**22/01340/OUT**

**Location: OS Parcel 6124 East Of Baynards Green Farm Street To Horwell Farm Baynards Green**

**Proposal: Application for outline planning permission (all matters reserved except means of access (not internal roads) from b4100) for the erection of buildings comprising logistics (use class b8) and ancillary offices (use class e(g)(i)) floorspace; energy centre, hgv parking, construction of new site access from the b4100; creation of internal roads and access routes; hard and soft landscaping; the construction of parking and servicing areas; substations and other associated infrastructure.**

**Objection:**

**Plan EDP 4: Breeding Bird Survey May 2018**

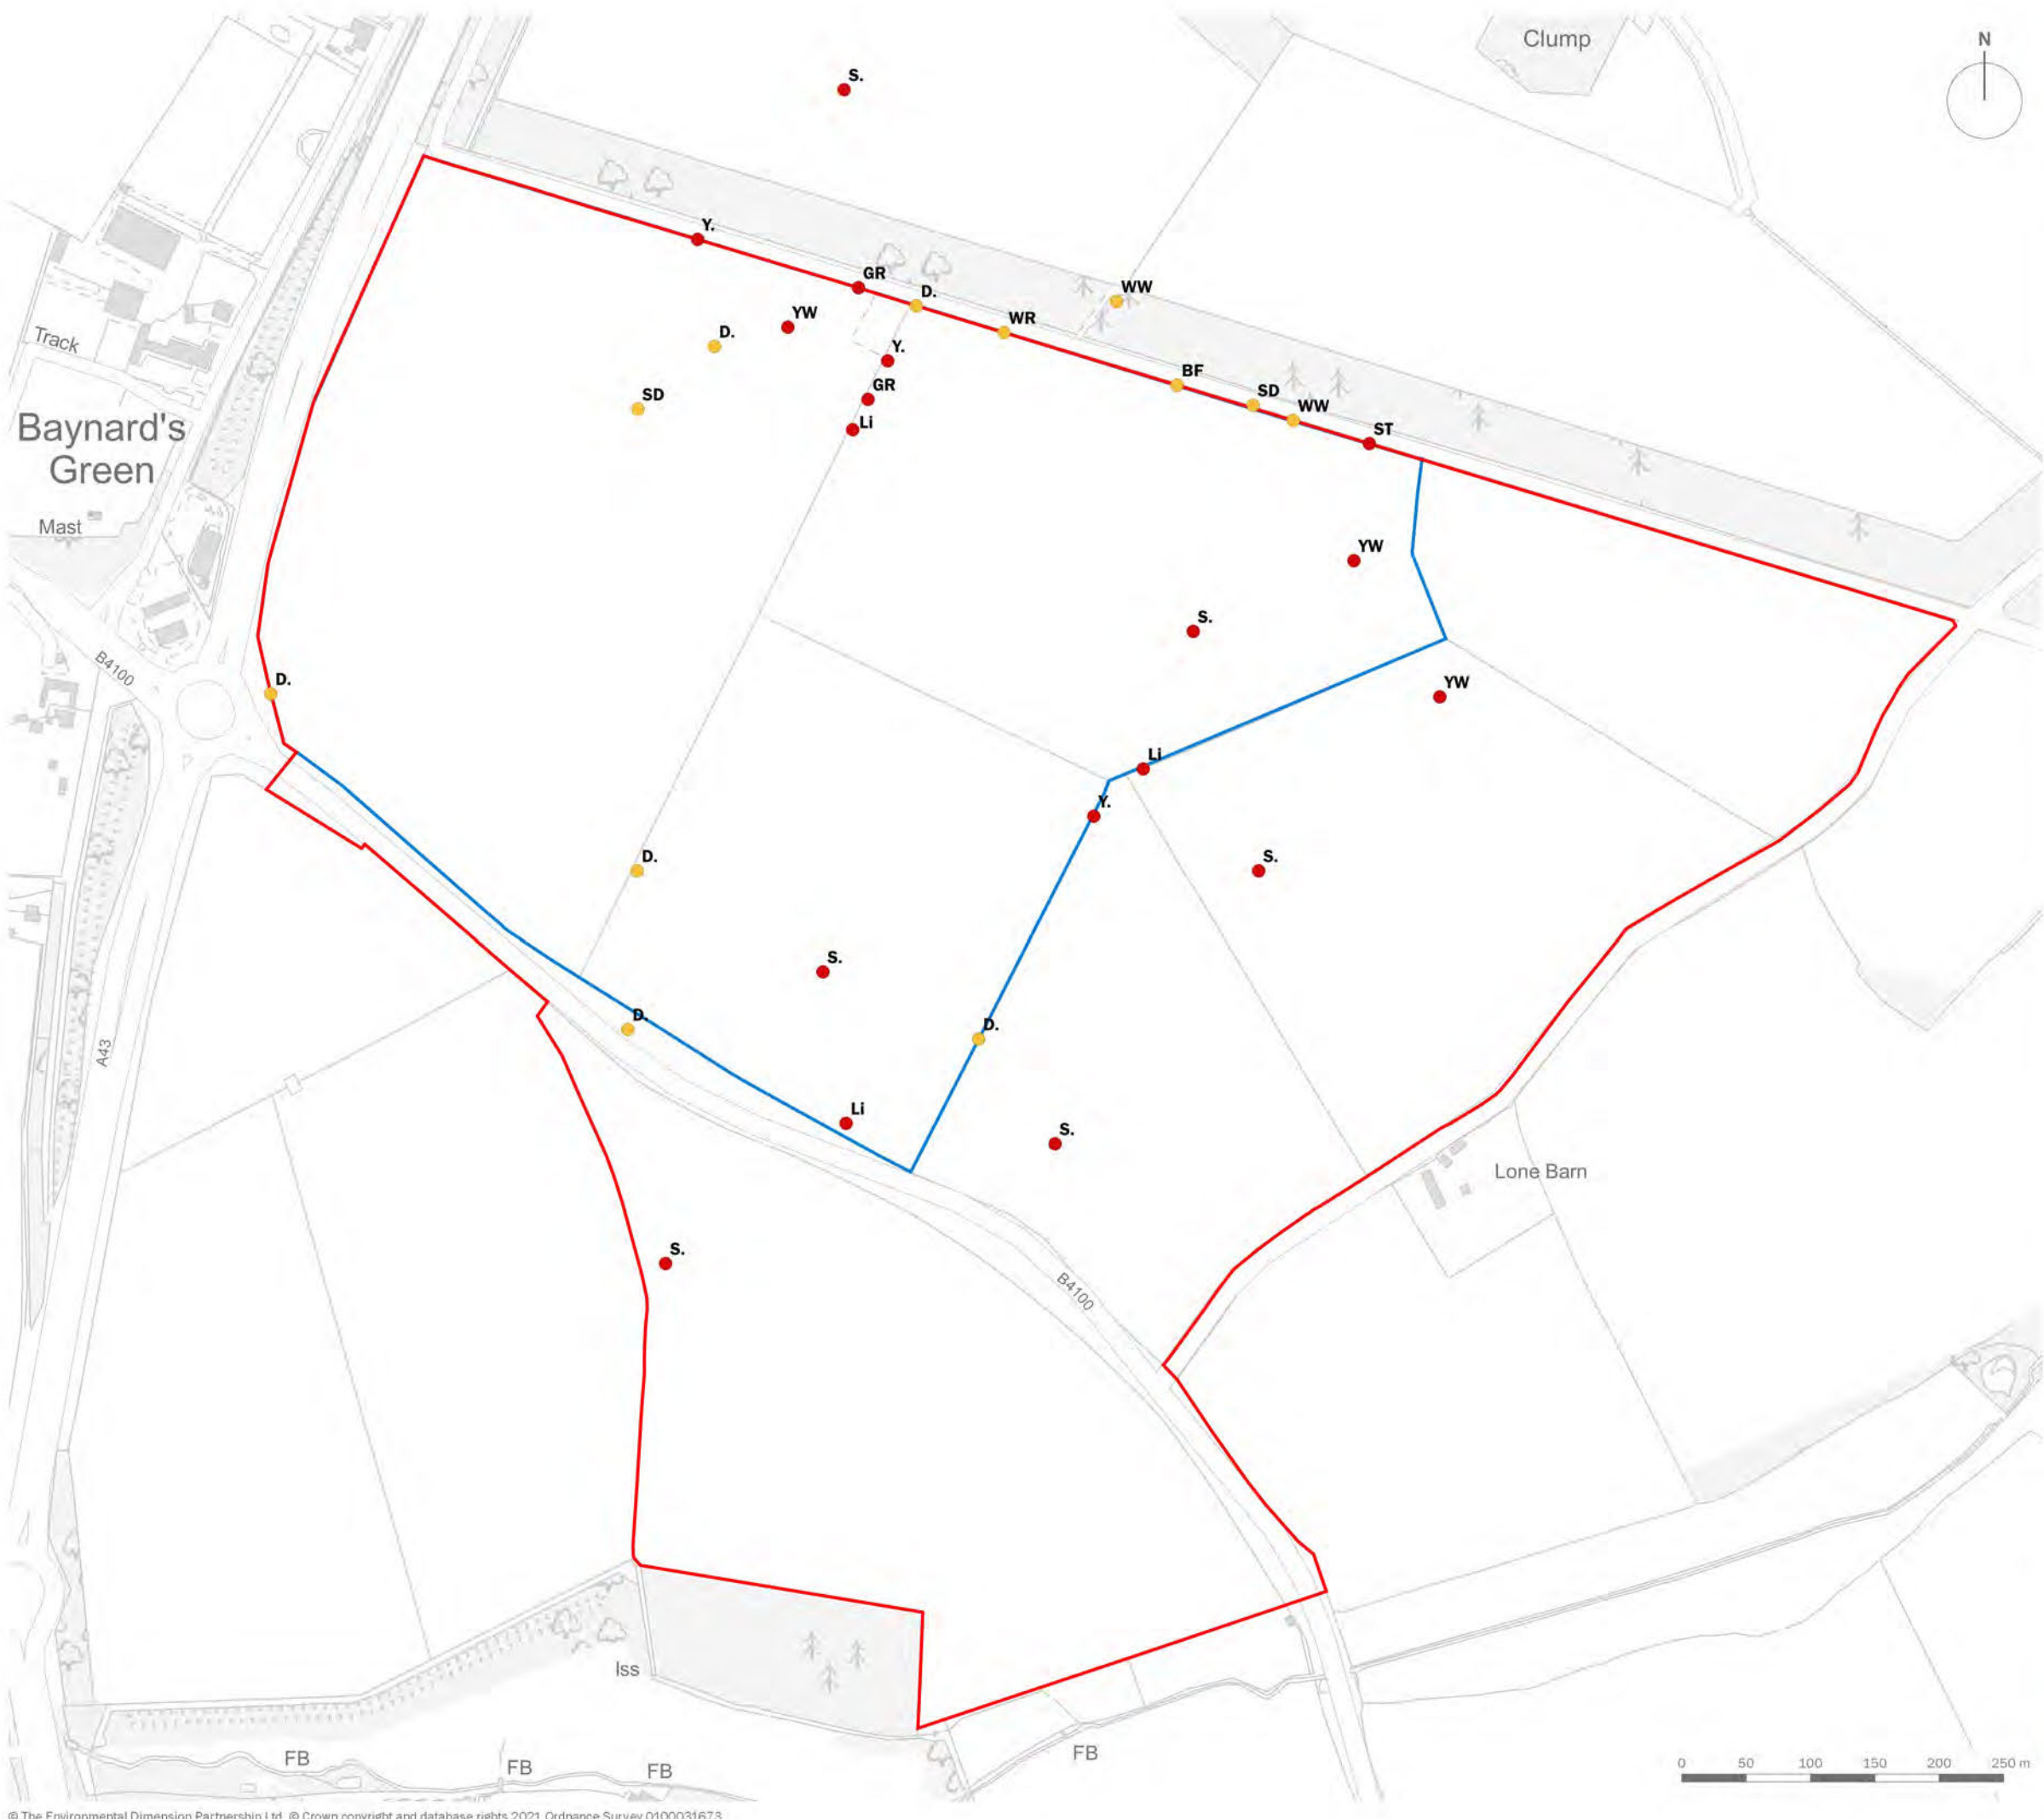
We are greatly concerned by the significant loss of wildlife habitat used by farmland birds that this development would lead to with the current design.

**Appendix 08.1 Ecological Baseline Table EDP A3.3** lists a number of protected/notable bird species which were present during surveys of the site. The red list species, which are also Species of Principle Importance (SPI) and protected under Section 41 of the NERC Act (2006), found at the site are linnet and yellow wagtail (possibly breeding), skylark (probably breeding), starling and yellowhammer (confirmed breeding). Other red list species swift (not breeding) and greenfinch (possibly breeding) were also found at the site.

The report identifies, for example, that up to six individual skylark were recorded in song at the same time and that it is probable that *'the Site supports a small population (0-6 pairs).'* This is a species which experienced more than a 50% decline in the 1990's, and it is still declining. We consider the loss of habitat for this number of pairs without specific farmland bird mitigation as unacceptable.
